Consultation Response from: KC Environmental Health (Pollution & Noise Control)
2023/91210 - Thornton And Ross Ltd, Manchester Road, Linthwaite, Huddersfield, HD7 5QH
Discharge condition 6 (noise barriers), 7 (finishes colour of plant and dimensions of pump and chiller) on previous permission 2021/92779 for erection of plant deck consisting of new heating, ventilation and air conditioning system (HVAC) with associated works
**Responding Date:
02 April 2024**
**Responding Officer:
Mohammed Nasim**
**Responding Ref:
WK202407515**
Comments

Recommendations
Condition 6 (Noise Barriers)

Document Number
AAA5581-RPS-XX-XX-DR-A-0010

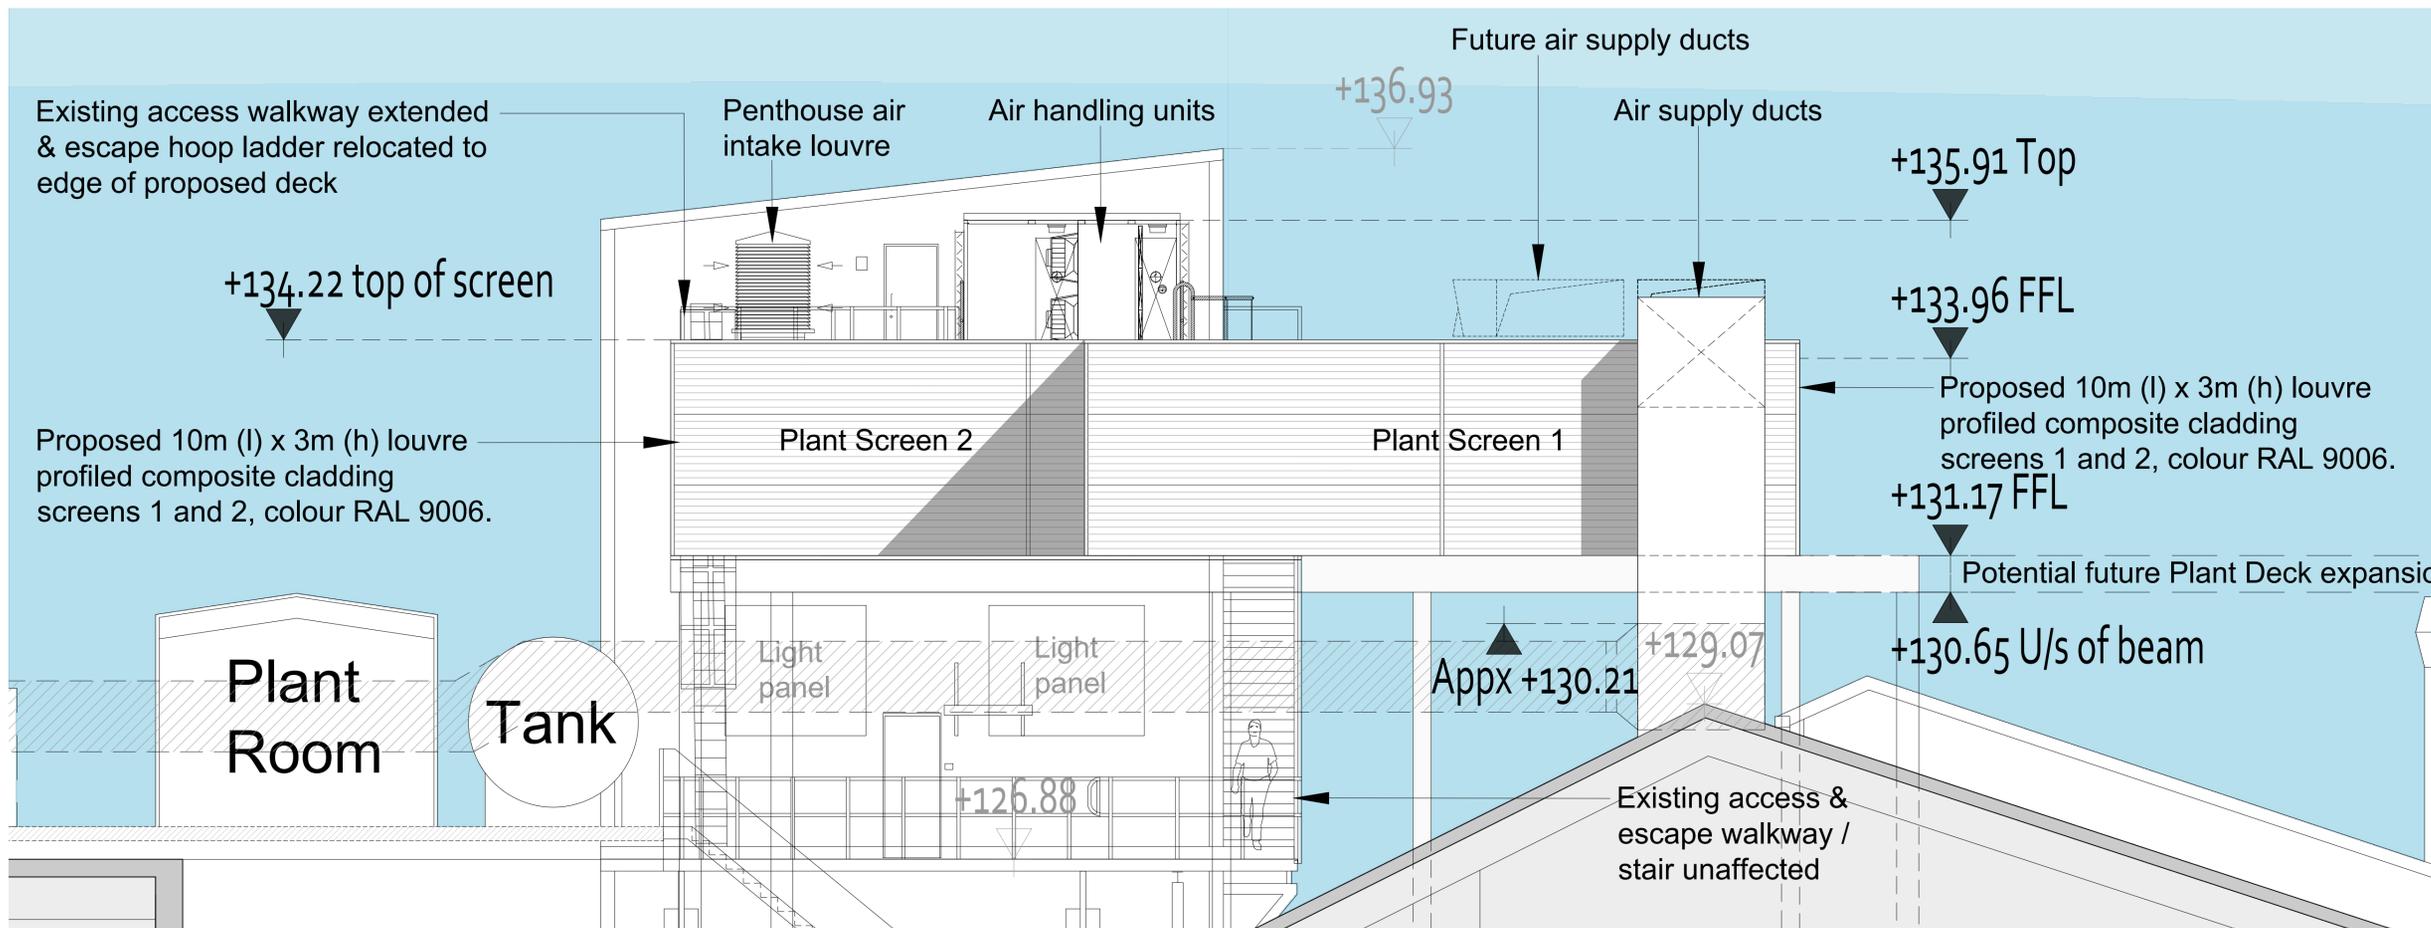
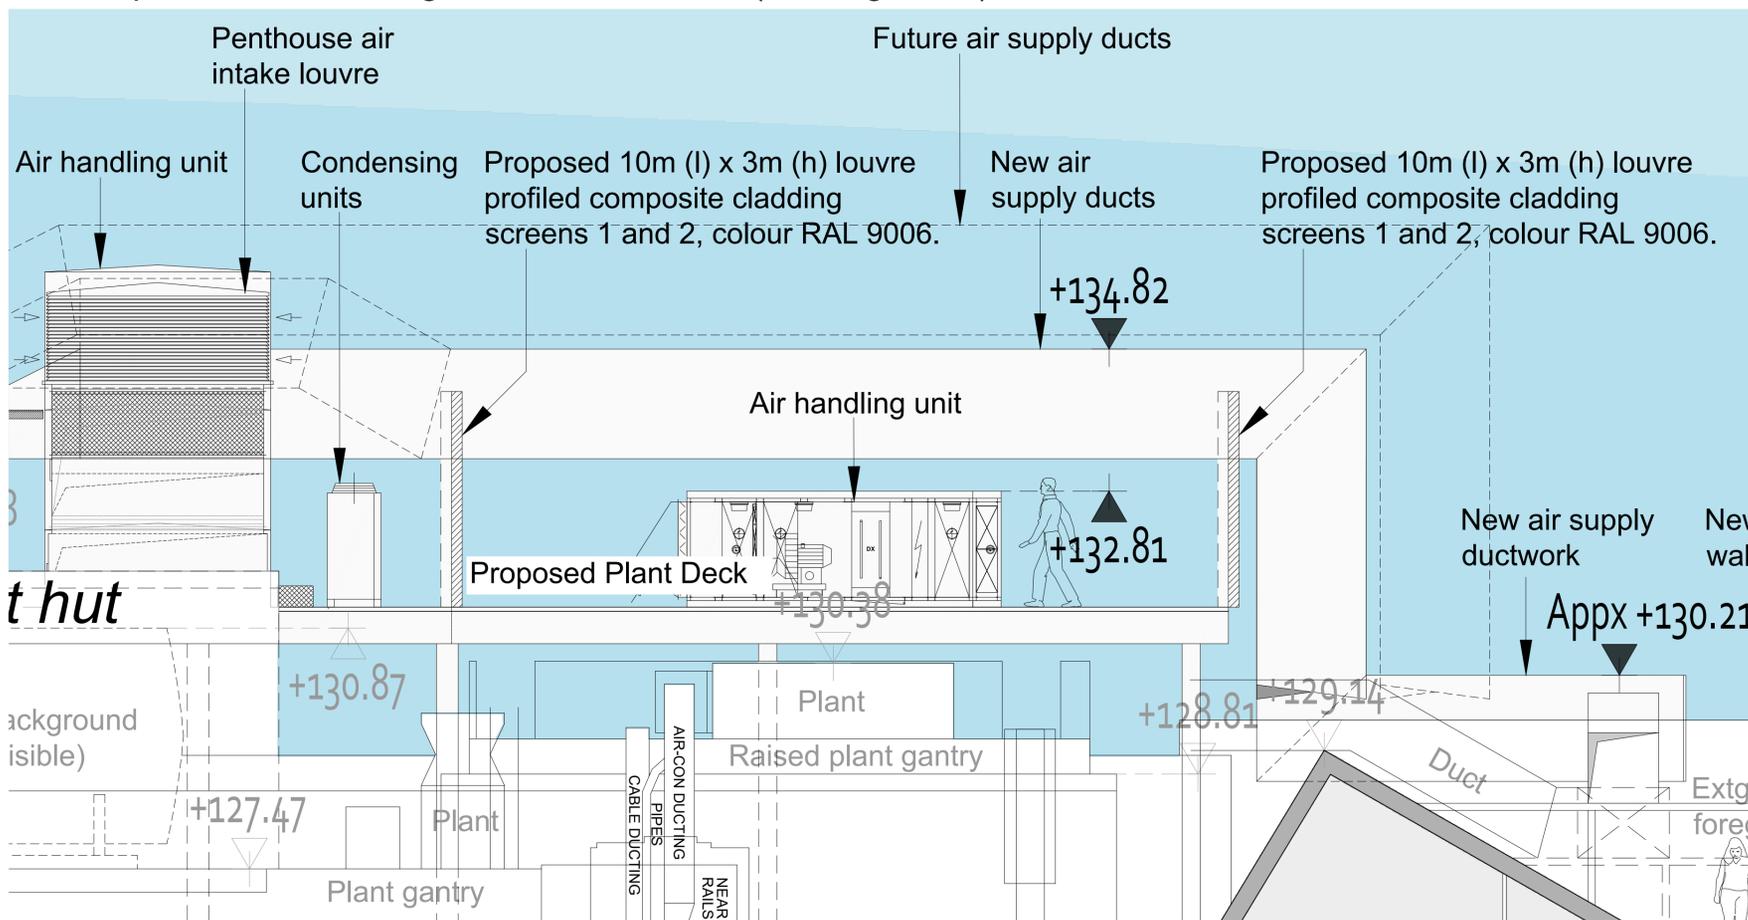
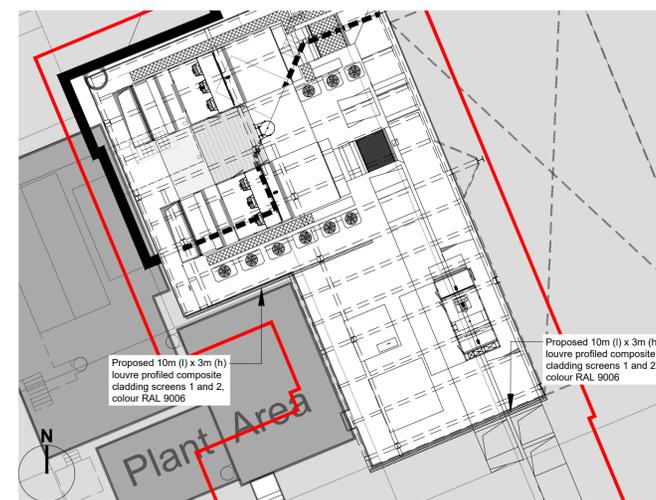
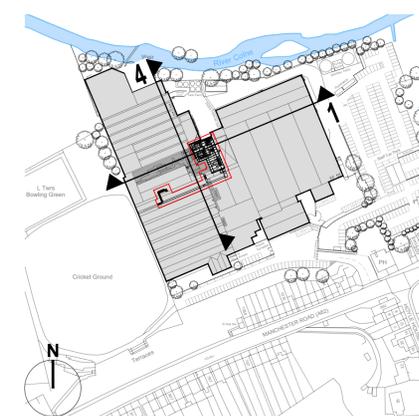
The findings of the report are accepted. However, we recommend the condition is not discharged until all mitigation measures identified within the Technical Note from RPS dated 05 March 2024 are installed and retained thereafter.
